Your Ref:
Our Ref: EP/17/09/
Please ask for:
Mr J Smith

Three bedroom detached house in the land North of Seaside Cottage
Land North Of Seaside Cottage South Strand East Preston

At the meeting held on Monday, 23rd February, the Planning Committee of this Council wished to comment on this Application as follows. ☐

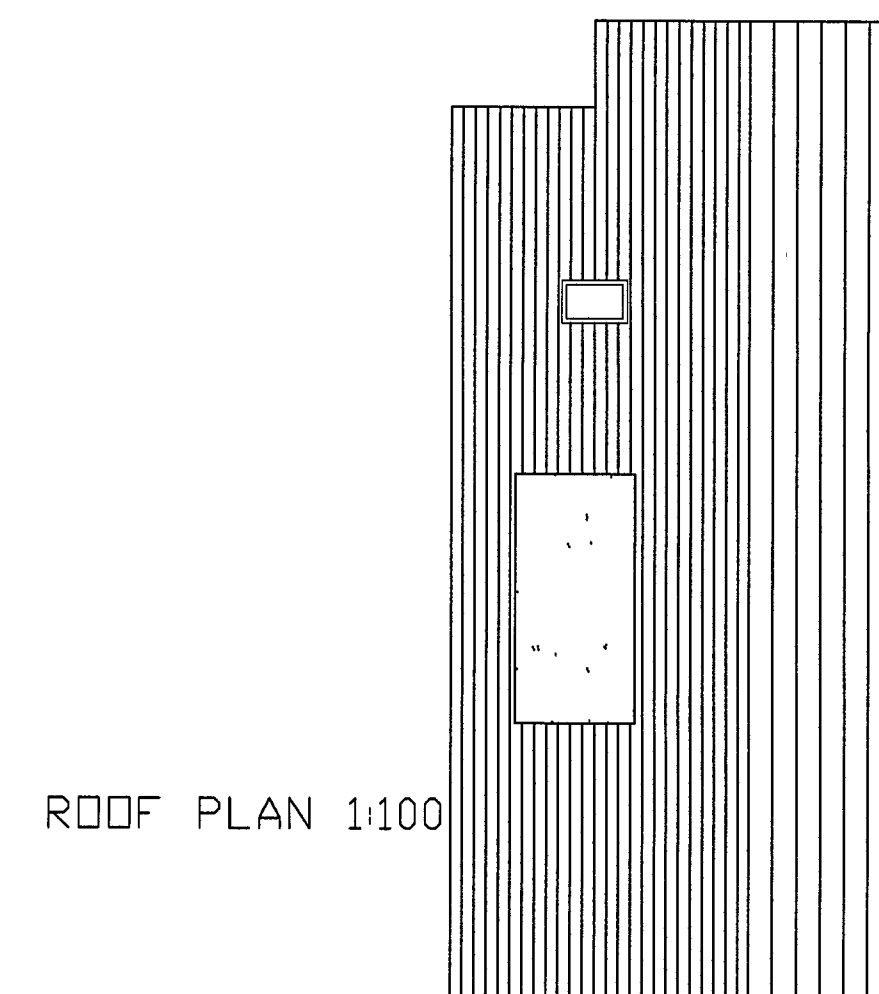
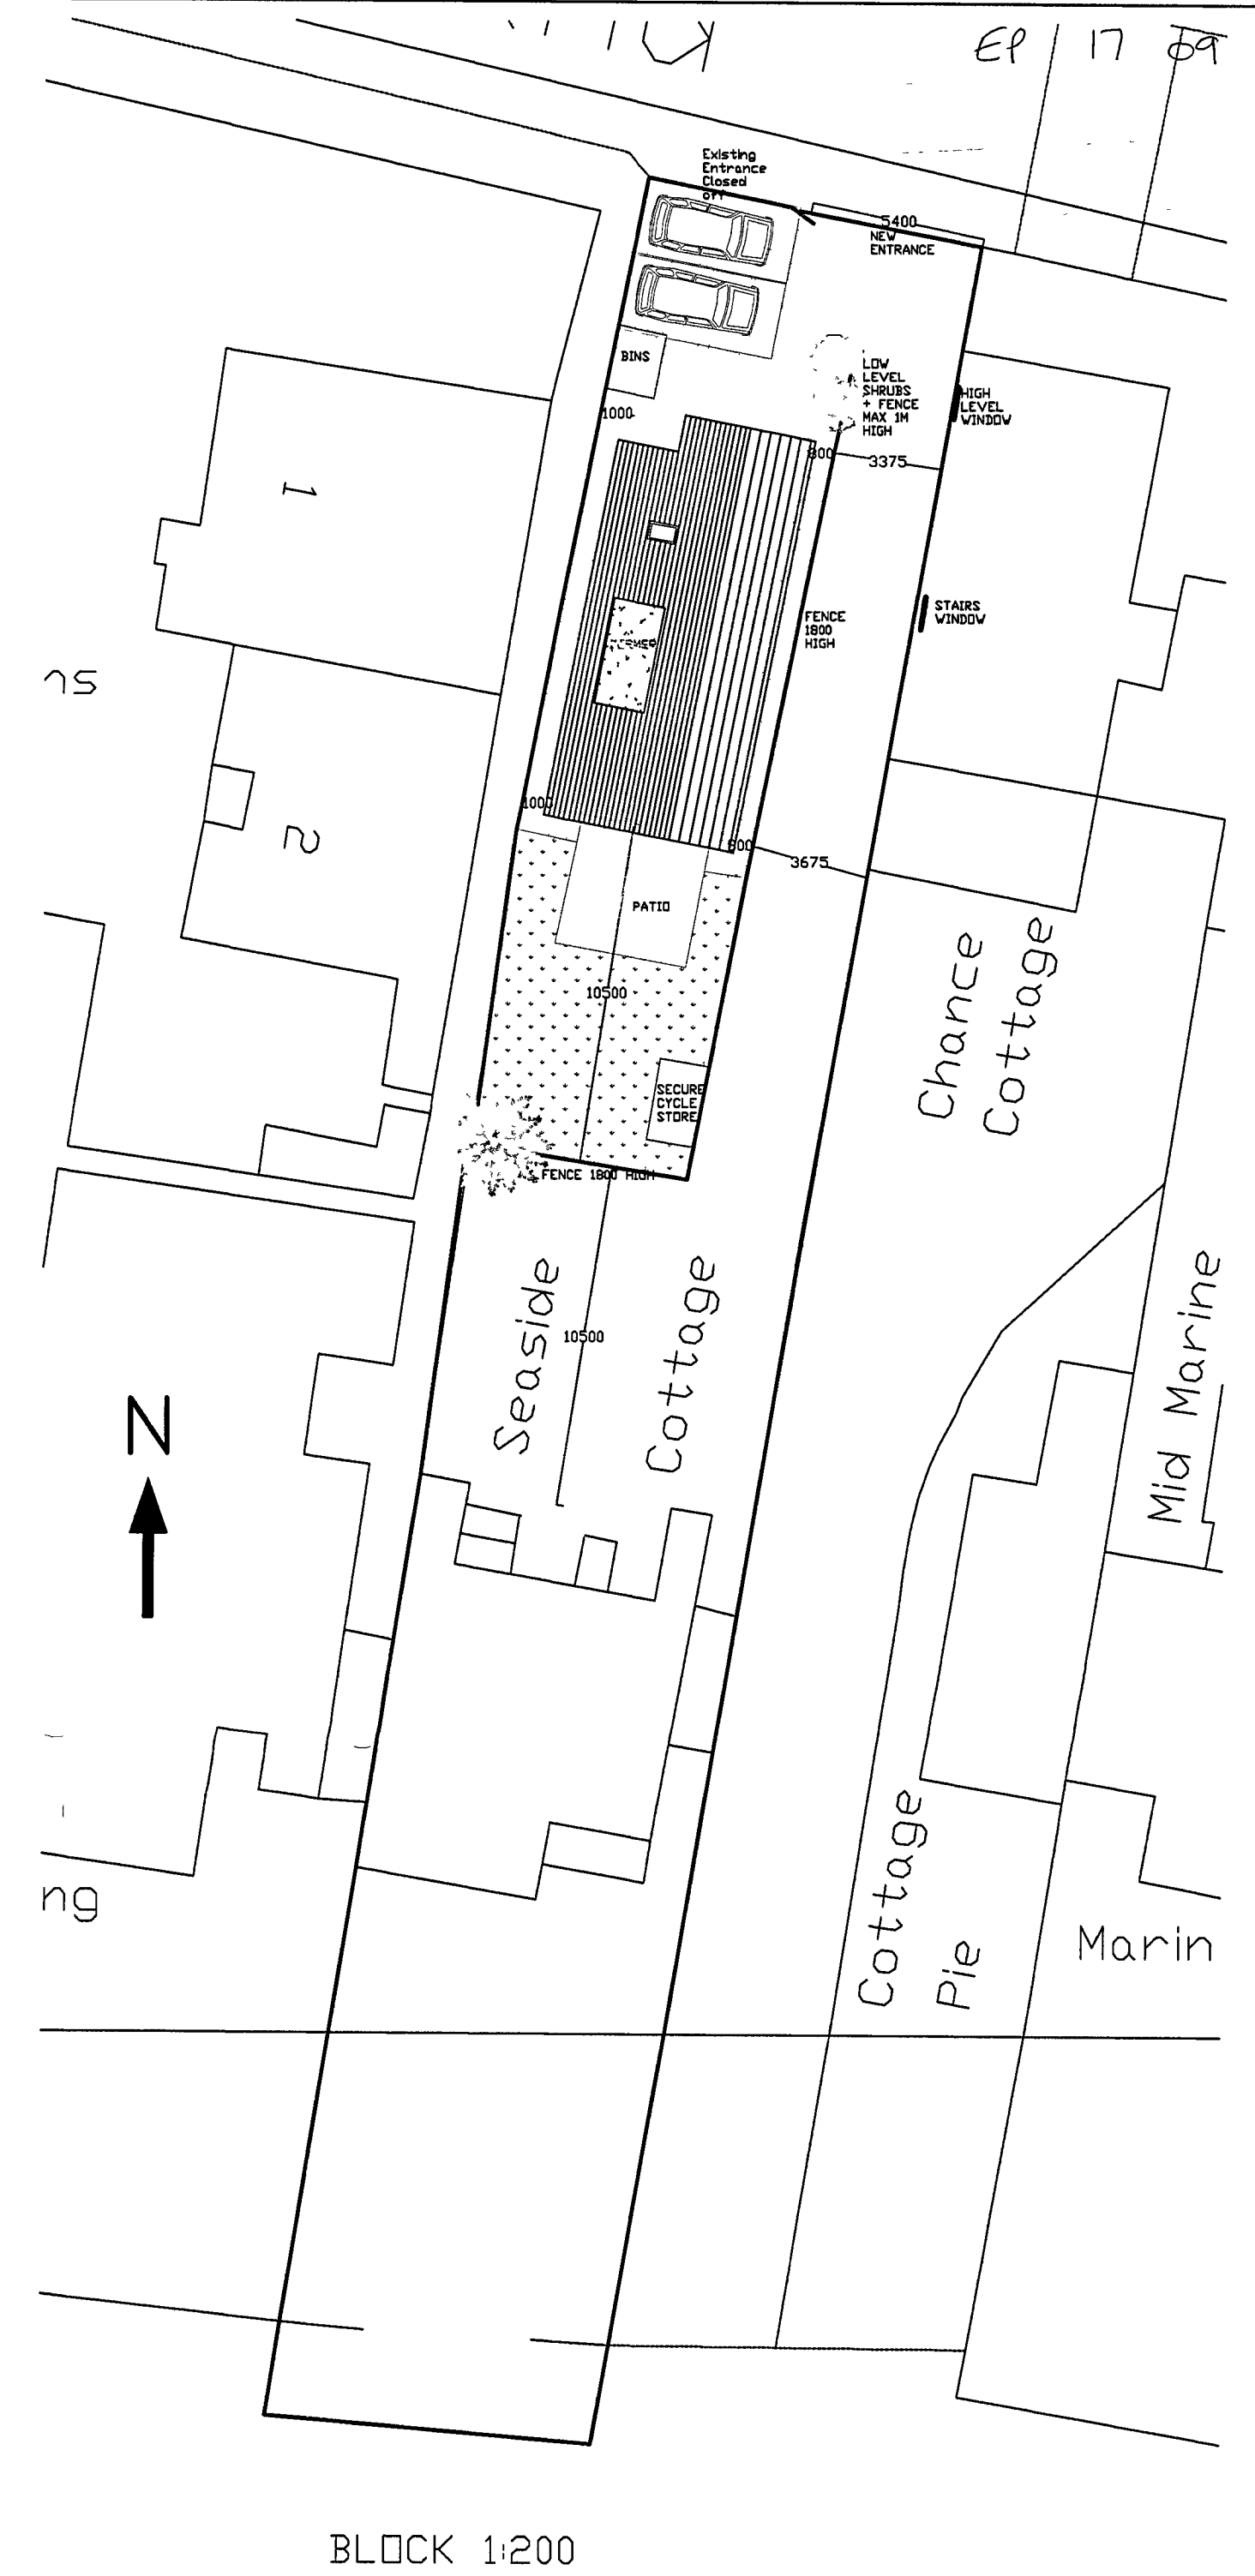
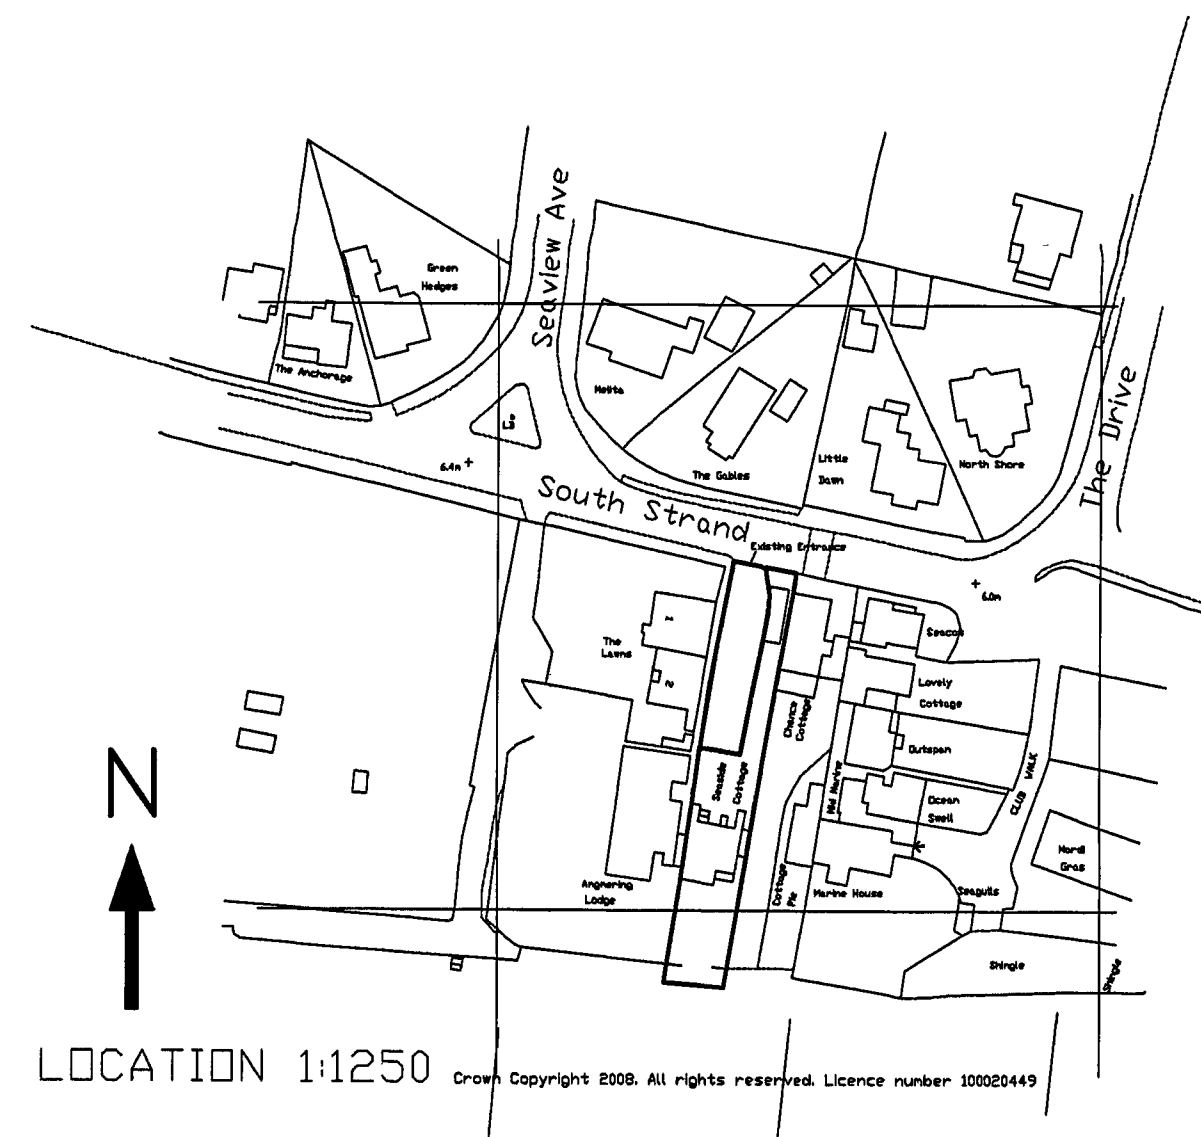
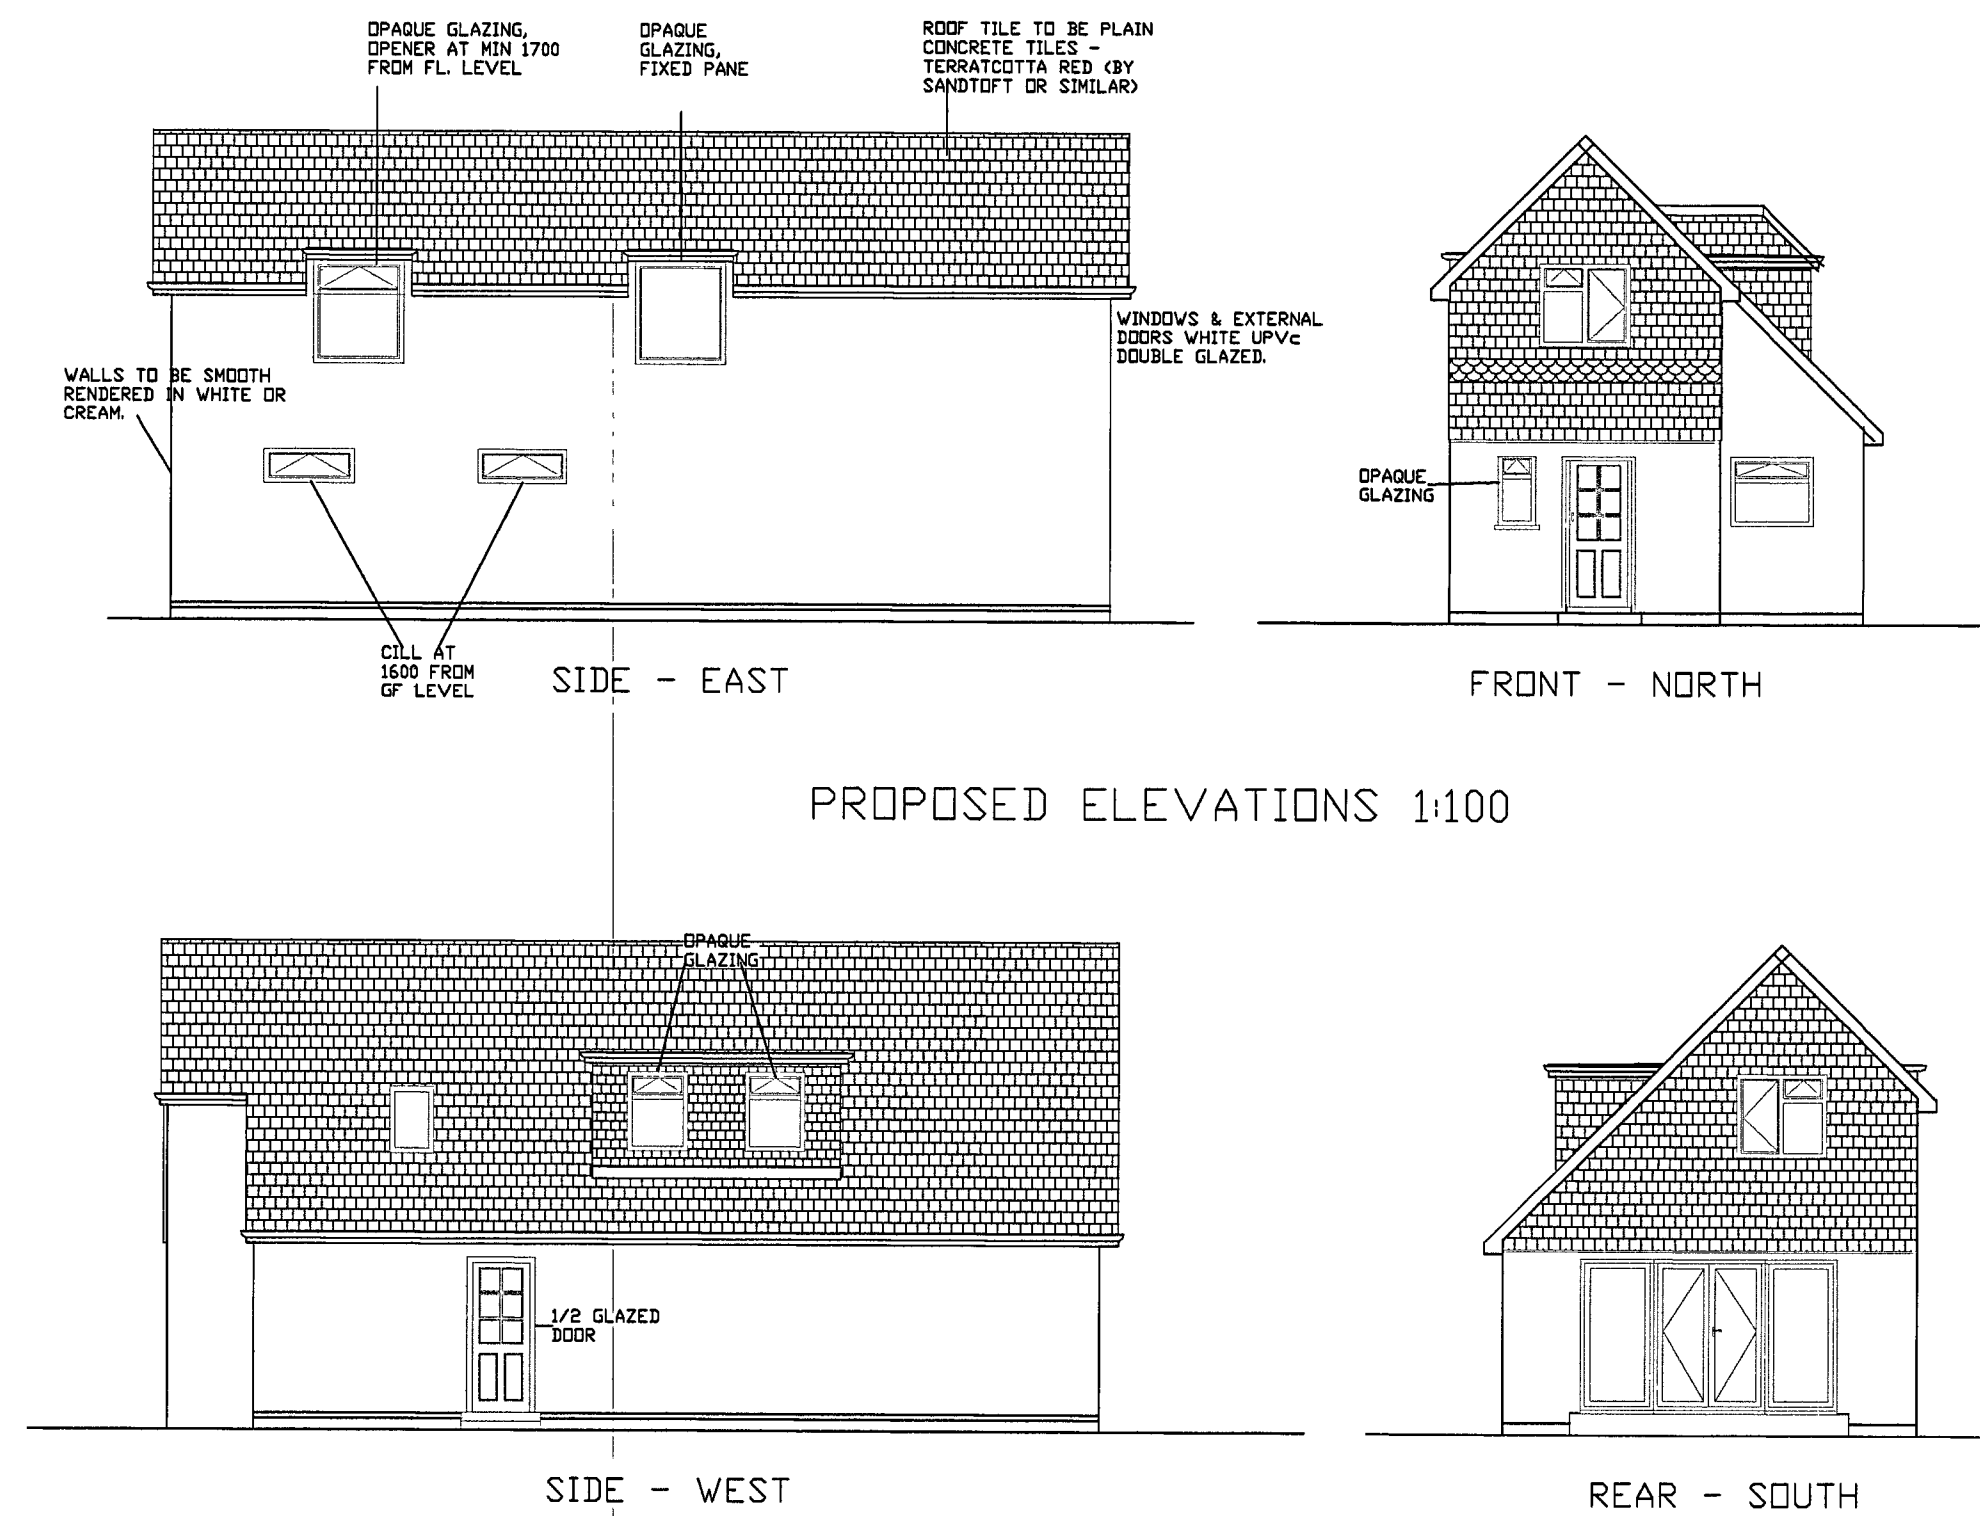
☐ *1. The proposed development is located in the area known as Angmering-on-Sea which is a private estate characterised by mainly detached houses built on relatively large plots with large gardens. The proposed in-fill development would result in the unacceptable loss of an important part of a garden and would have a detrimental impact on the character and appearance of the locality.* ☐

☐ *2. The site by reason of its size is considered unsuitable to accommodate a dwelling and private amenity space without damaging the character of the area. The cramped nature of the dwelling would also be detrimental to neighbouring outlook and would harm the existing street scene, contrary to Policies G1, G5 and B1 of the West Sussex Structure Plan and GEN 7 of the Arun District Local Plan.* ☐

☐ *3. The proposed development would be visually intrusive and un-neighbourly and would have a materially adverse effect on the residential amenities of adjoining properties.* ☐

☐ *4. The development would lead to overlooking, loss of light and adversely affect the privacy and quiet enjoyment of neighbouring properties contrary to Policy DEV1 of the West Sussex Structure Plan and GEN7 of the Arun District Local Plan.* ☐
